City of Portland, Maine - Building or Use Permit Application
 389 Congress Street, 04101 Tel: (207) 874-8703, Fax: (207) 874-8716

Permit No: 05-1710	Issue Date:	CBL: 087 Z025001
------------------------------	--------------------	----------------------------

Past Use: Single Family	Proposed Use: Single Family add second floor for bedroom and bath	Permit Fee: \$273.00	Cost of Work: \$28,000.00	CEO District: 2
Proposed Project Description: Add second floor for bedroom and bath		FIRE DEPT: <input type="checkbox"/> Approved <input type="checkbox"/> Denied	INSPECTION: Use Group: Type	
		Signature:	Signature:	
PEDESTRIAN ACTIVITIES DISTRICT (P.A.D.)				
Action: <input type="checkbox"/> Approved <input type="checkbox"/> Approved w/Condition <input type="checkbox"/> Denied				
		Signature:	Date:

2<sup>ND</sup> FL. Addition AT  
ELIZABETH ST.  
PEAKS ISLAND ME

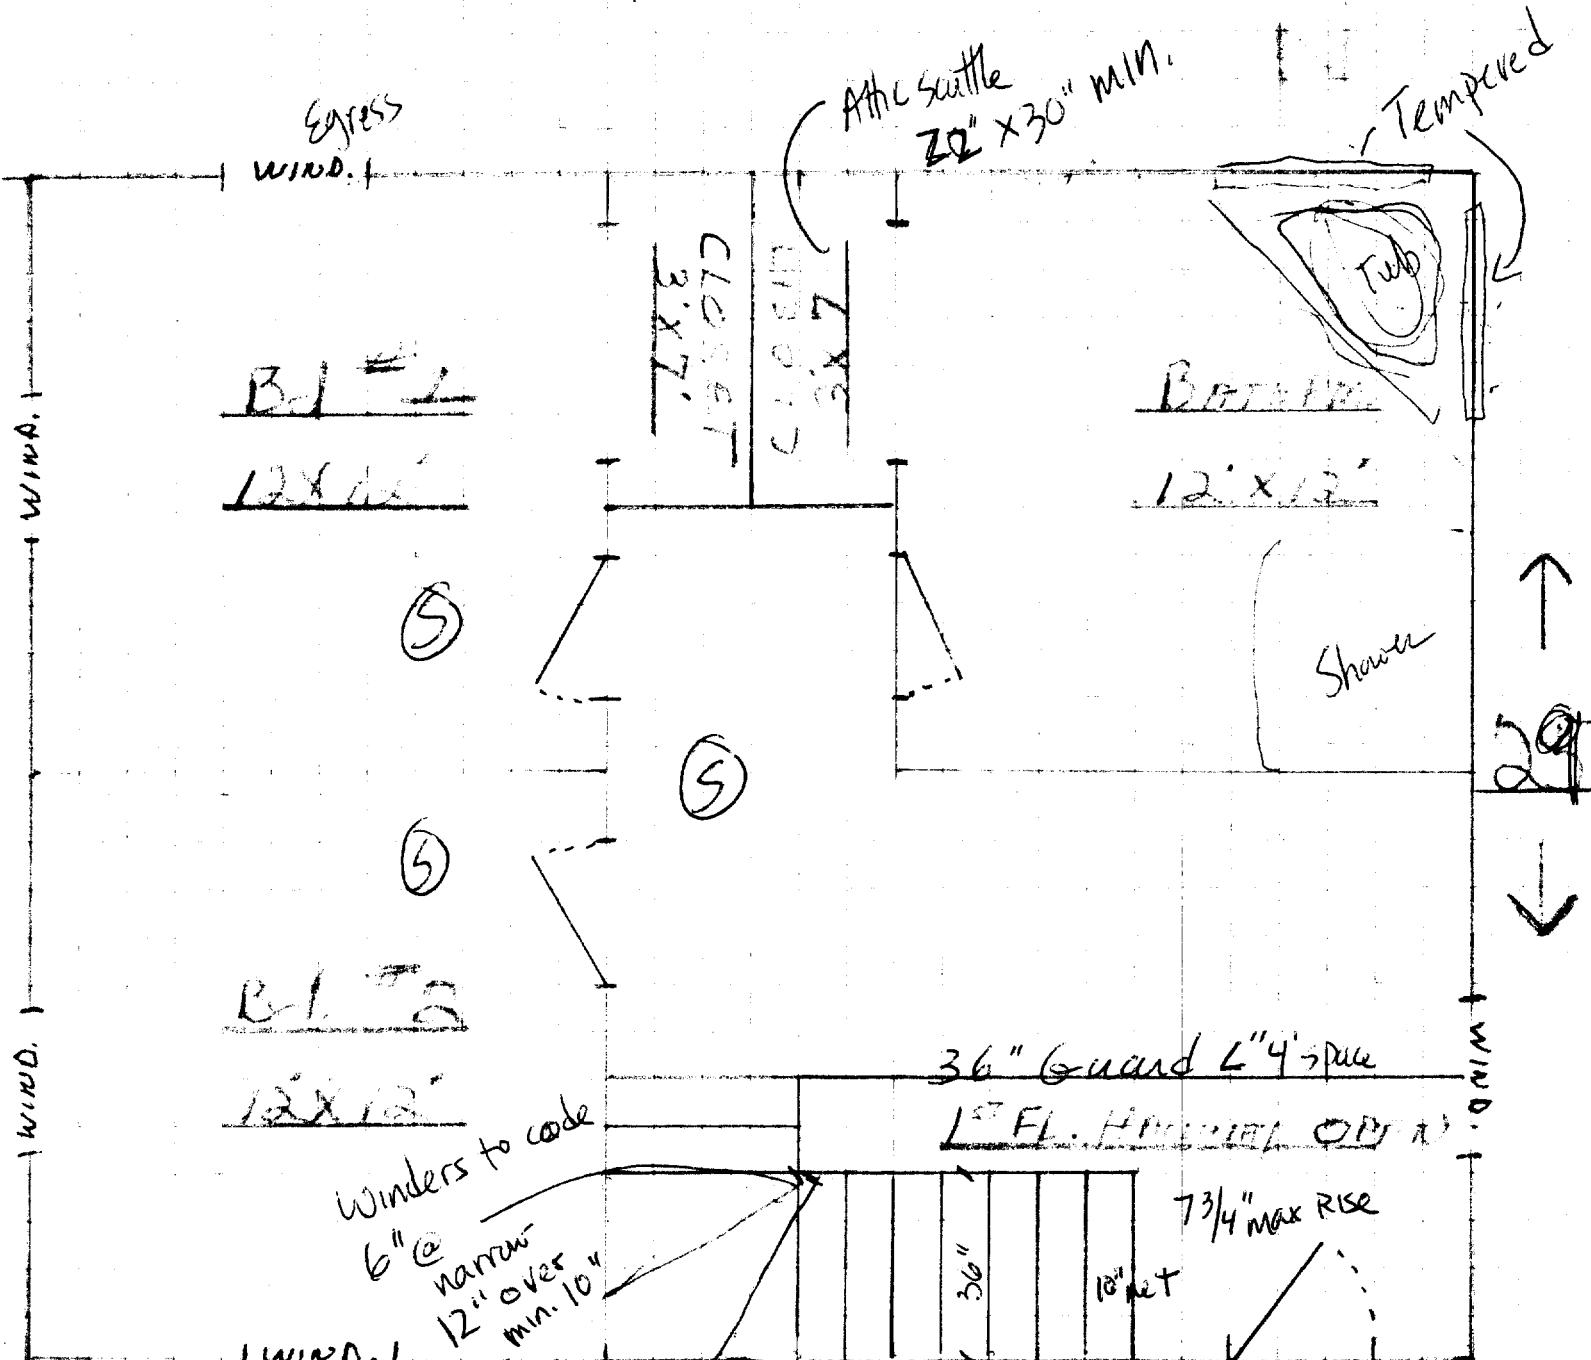
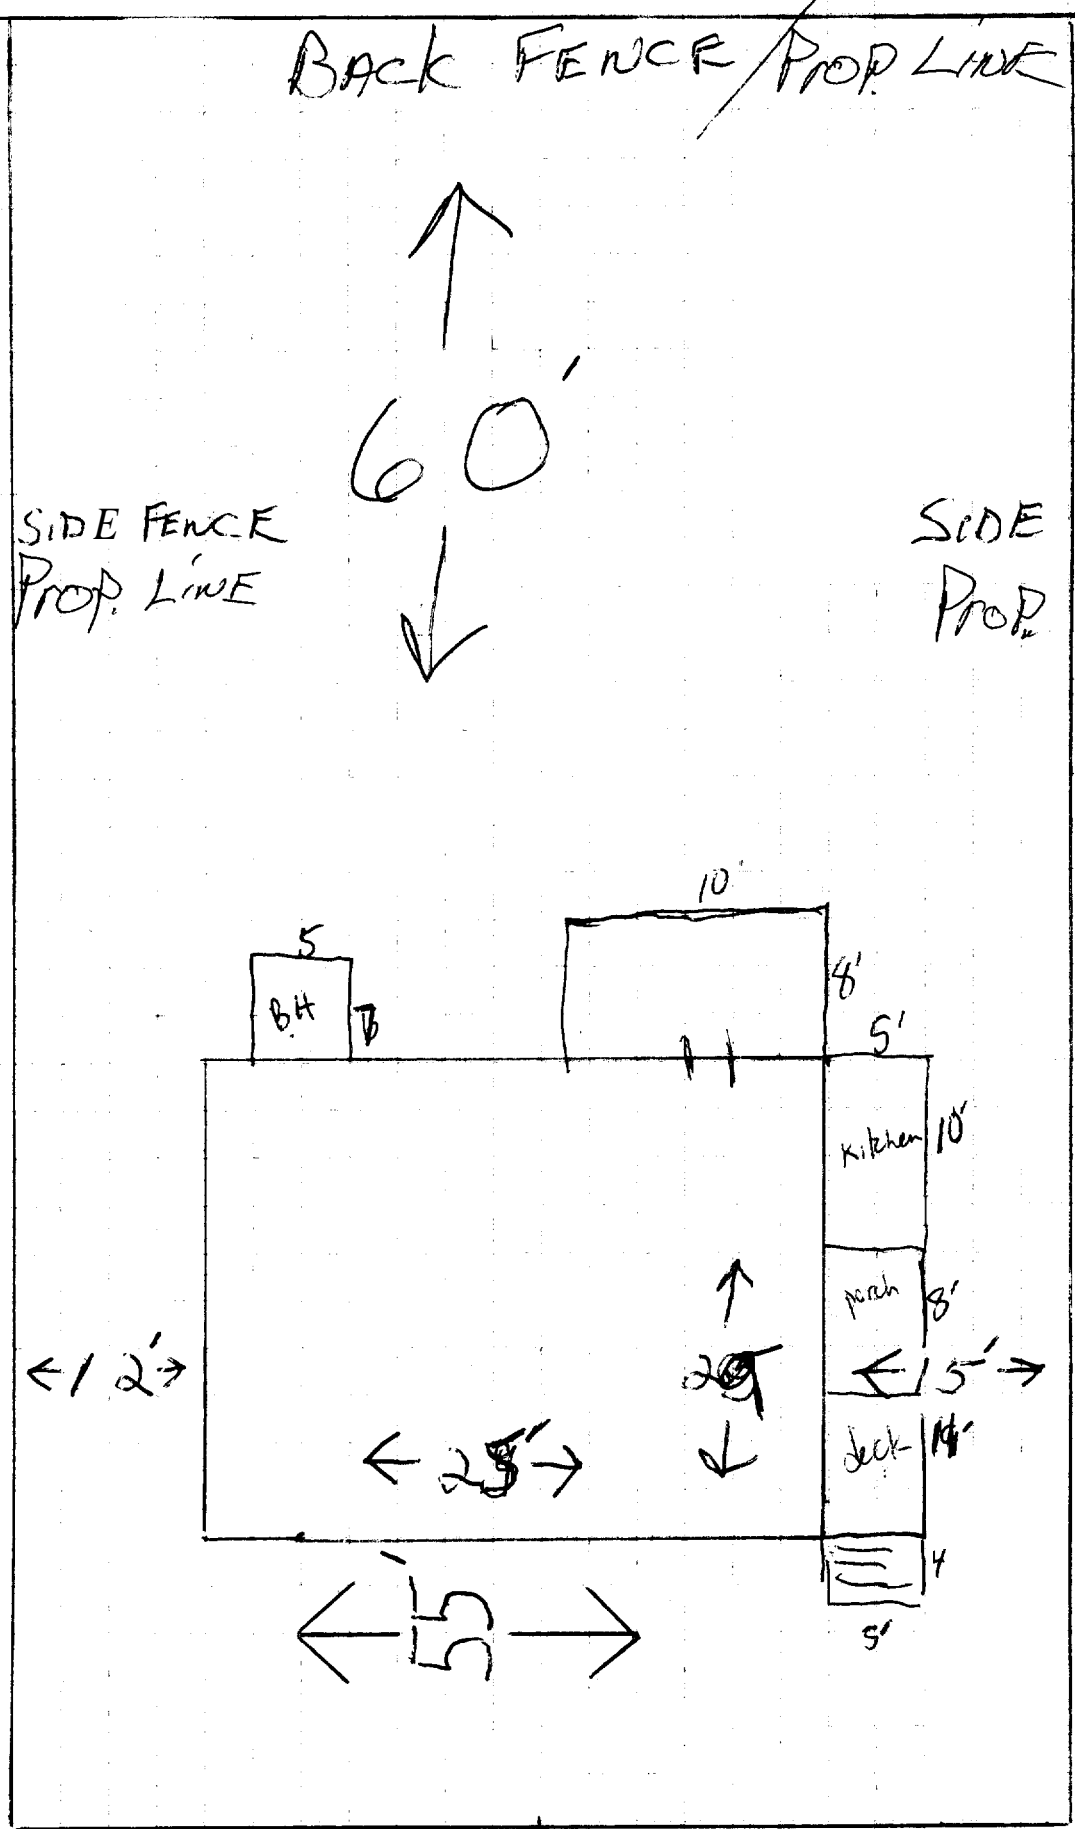
Dept: Building	Status: Approved with Conditions	Reviewer: Jeanine Bourke	Approval Date: 12/01/2005
Note:			Ok to Issue: <input checked="" type="checkbox"/>
1) There must be a 2" clearance maintained between the chimney and any combustible material, and fire blocking per code at each level			
2) Separate permits are required for any electrical, plumbing, or heating.			
3) Permit approved based on the plans submitted and reviewed w/owner/contractor, with additional information as agreed on and as noted on plans.			
4) As discussed, hardwired interconnected battery backup smoke detectors shall be installed in all bedrooms, on every level, and in a common area.

# Foot Print

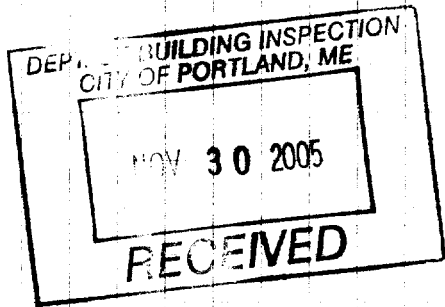
Dept: Zoning	Status: Approved with Conditions	Reviewer: Jeanine Bourke	Approval Date: 12/01/2005
Note:			Ok to Issue: <input checked="" type="checkbox"/>
1) Approved using Sec. 14-436 for a 50% expansion of the first floor footprint. The footprint will be increased to the maximum 20% with a front entry and a rear deck extension. This work will cause this property to have the maximum lot coverage allowed and the maximum expansion.			
2) This property shall remain a single family dwelling. Any change of use shall require a separate permit application for review and approval.

Comments:
11/23/2005-dmartin: Waiting for plot plan, left voicemail on 11/23/2005 / dm
11/28/2005-jmb: Left msg w/Lisa L. To call about the expansion limitations. Spoke to Frank O., explained the expansion rule, he would like me to get Marge's ruling.
11/29/2005-jmb: Lisa L. Came in to discuss expansion, she can increase the footprint per code to increase expansion. Also need sq.ft. In attic and more details on construction plans.
11/30/2005-jmb: Frank O. Came in with details of existing framing and attic dimensions. Still need details on front enty and rear deck. He will submit on 12/01
